Our ref: DOC22/216041

**Heritage NSW - Aboriginal Cultural Heritage - Environmental Impact Statement – Daroobalgie Solar Farm (SSD-10387)**

Thank you for your referral dated 17 March 2022, inviting comments on the Environmental Impact Statement (EIS) on the above State Significant Development (SSD) proposal, with respect to Aboriginal cultural heritage. Heritage NSW has reviewed *Daroobalgie Solar Farm Project - Aboriginal Cultural Heritage Assessment Report, Report to Pacific Hydro, Umwelt Environmental and Social Consultants, June 2021*, and makes the following comments.

FIGURE 6.2A

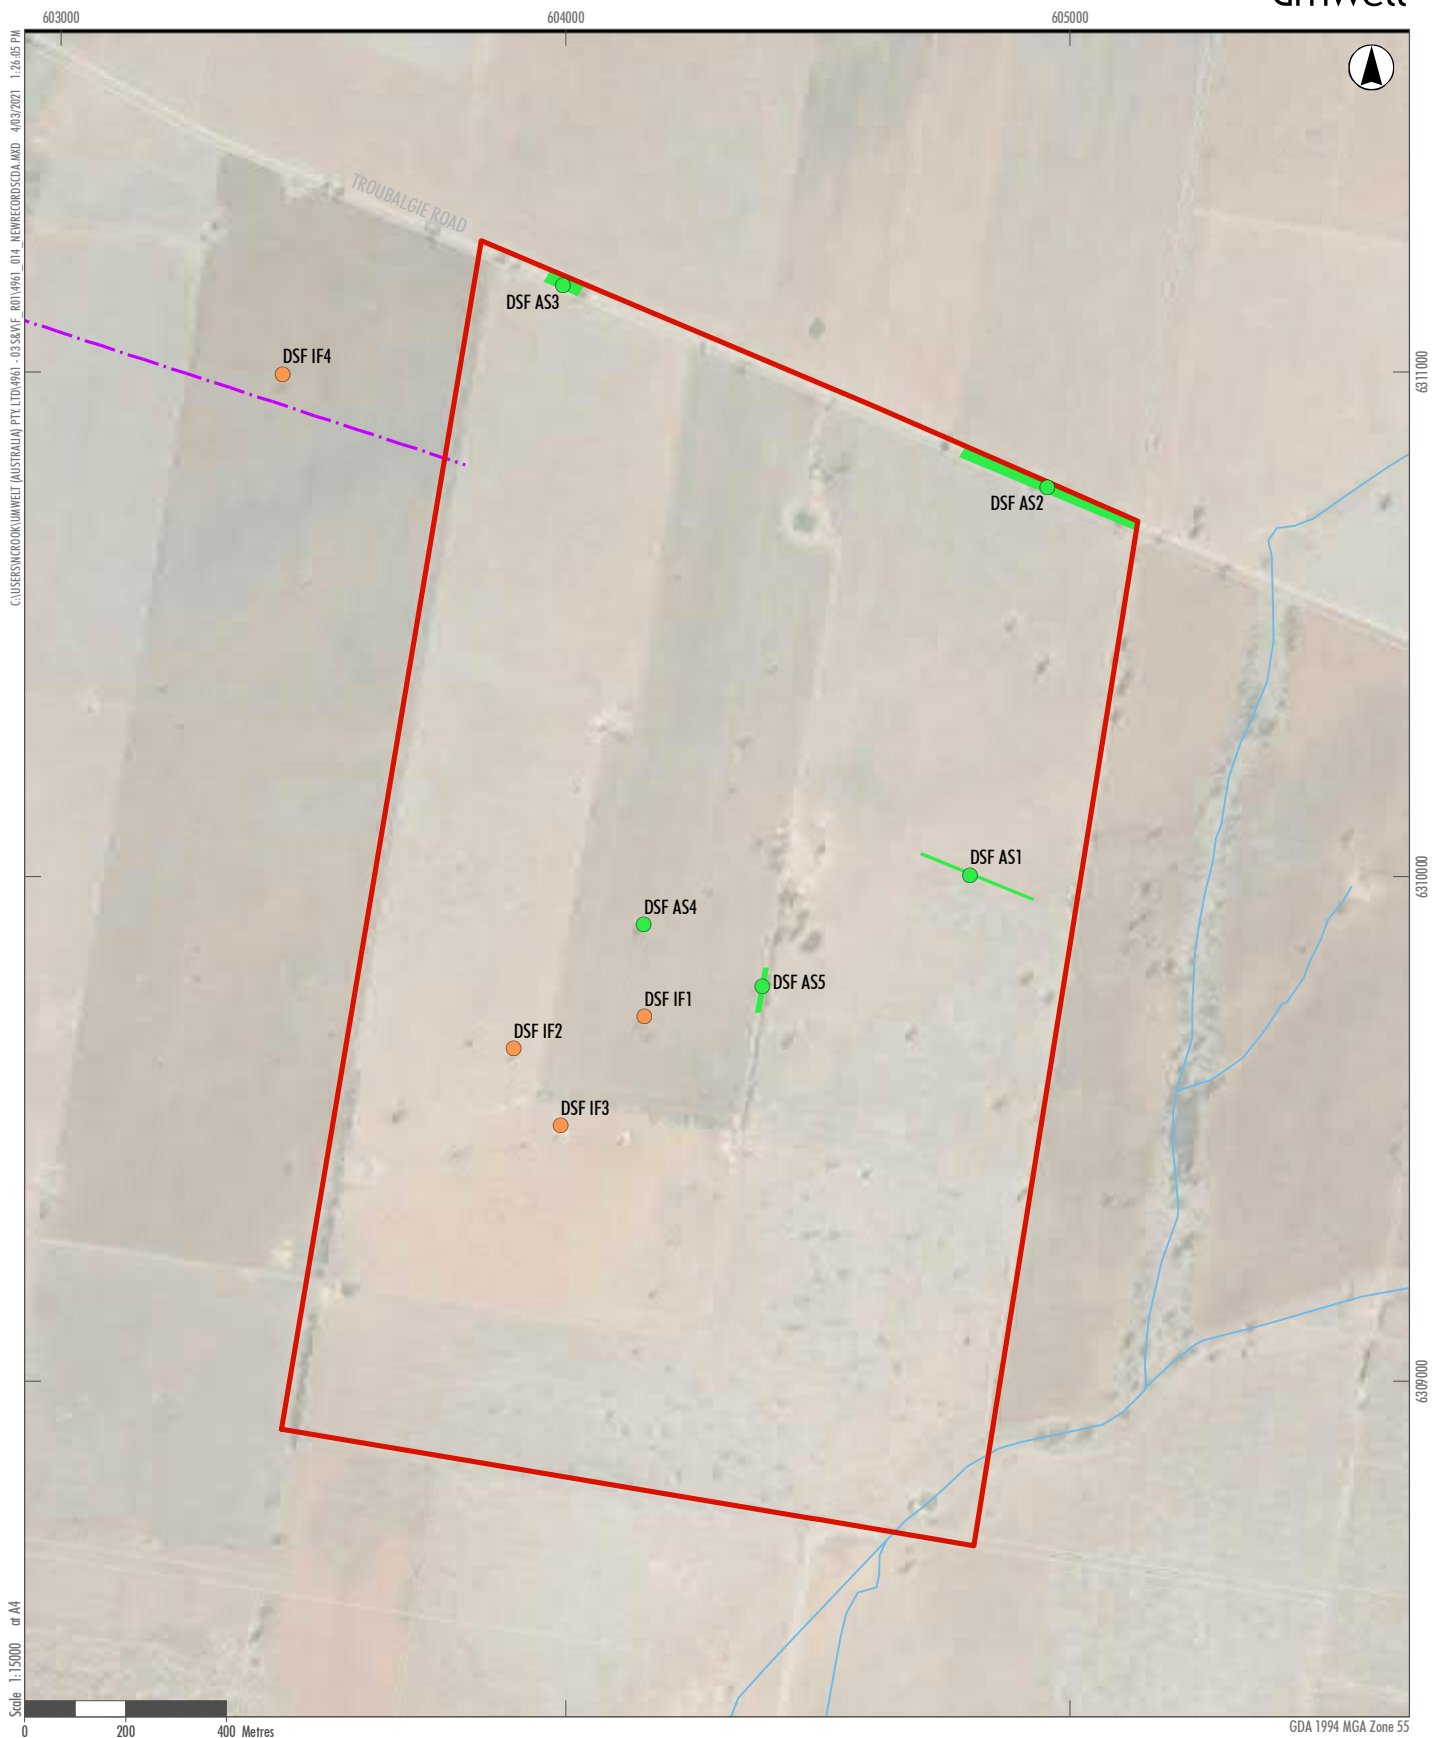
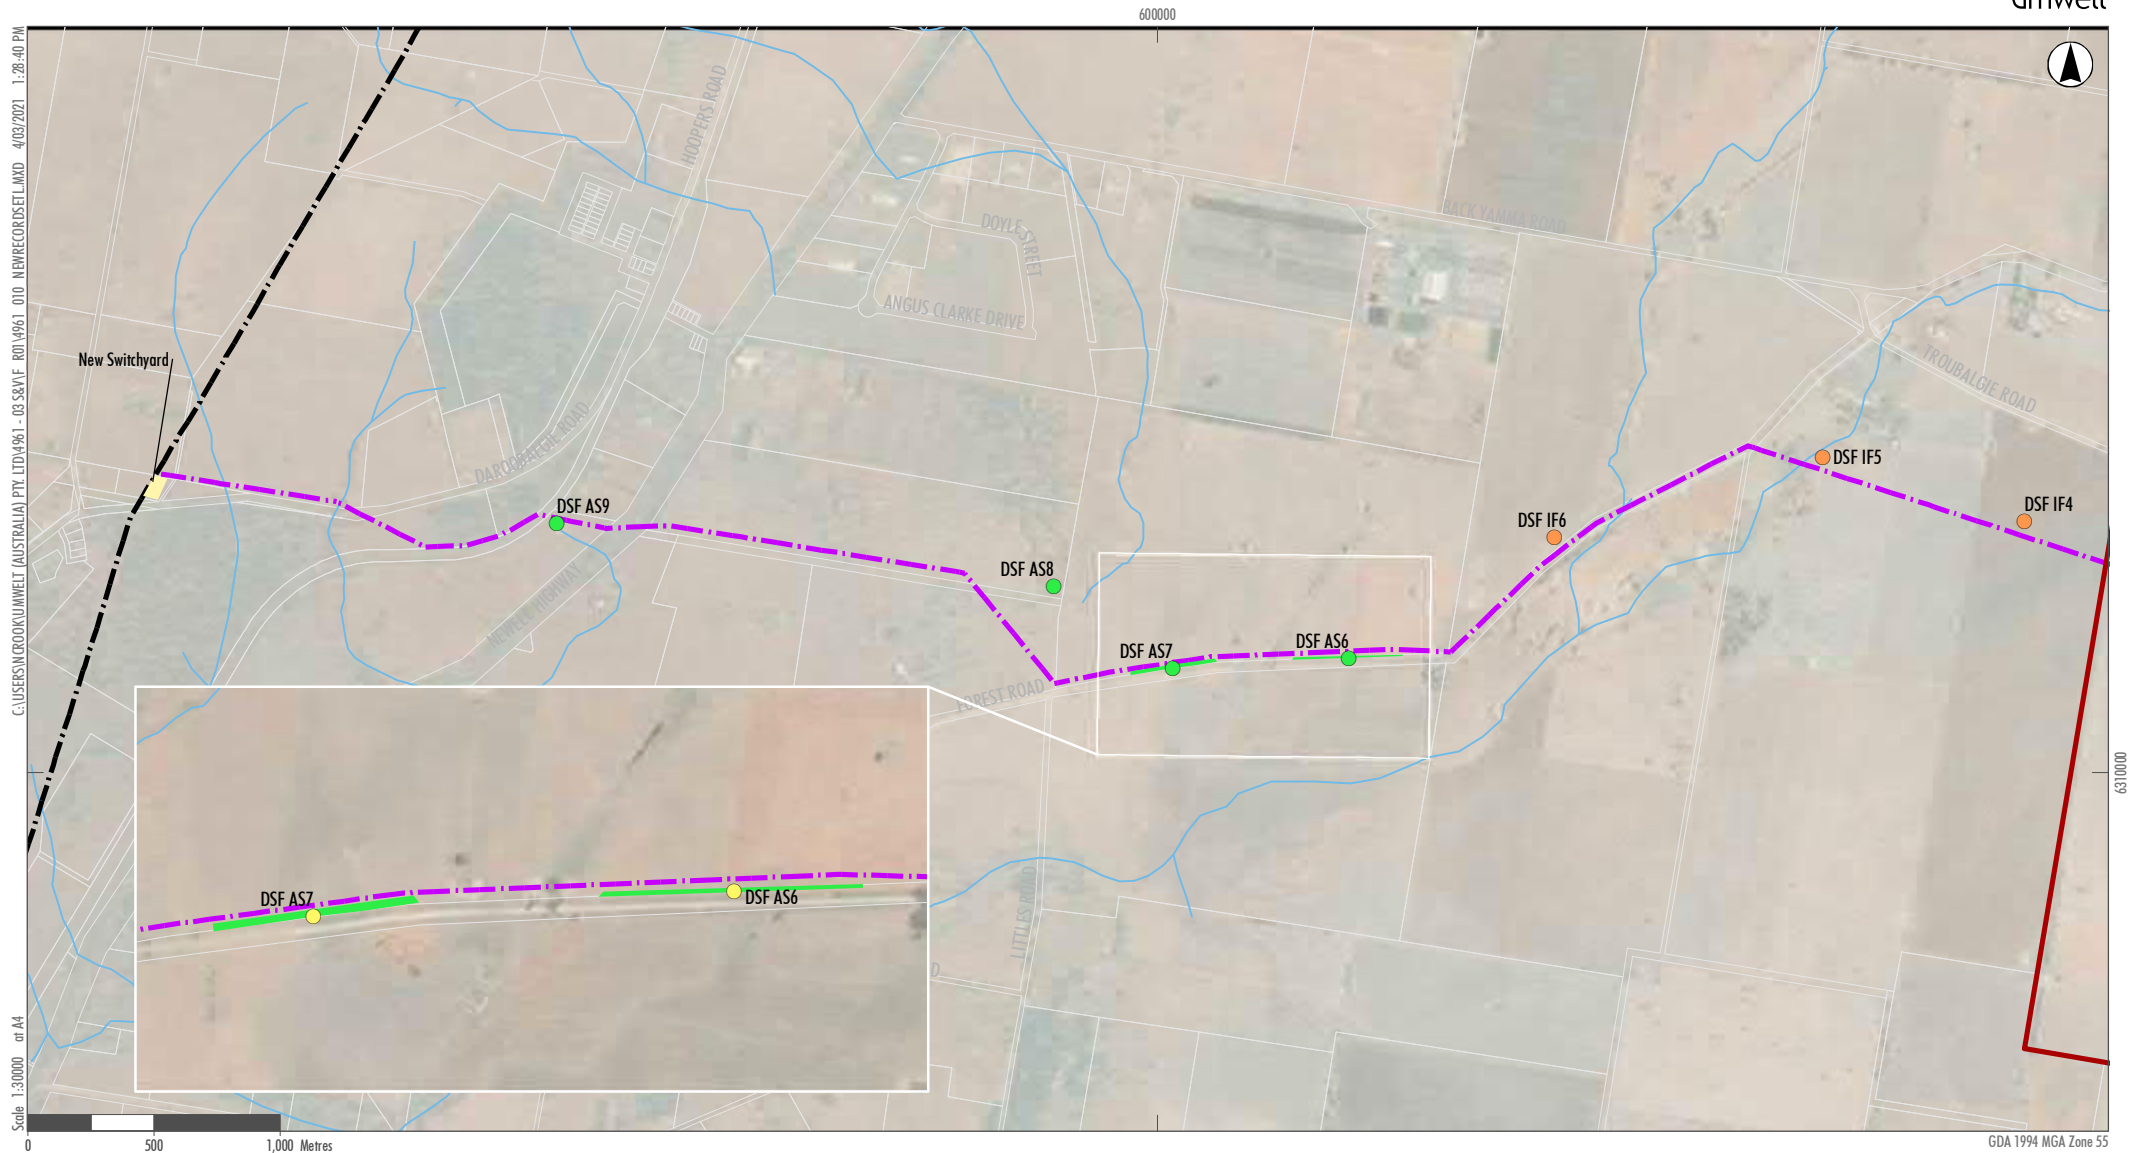
- Clarification is required on the location of artefacts within their respective site boundaries and in relation to the project area and proposed impacts. Several sites appear to be outside of the proposed SSD area and/or impact area. If these sites are not within the project area but may

be harmed through construction or other works then these sites may require an Aboriginal Heritage Impact Permit (AHIP) before any harm could occur.
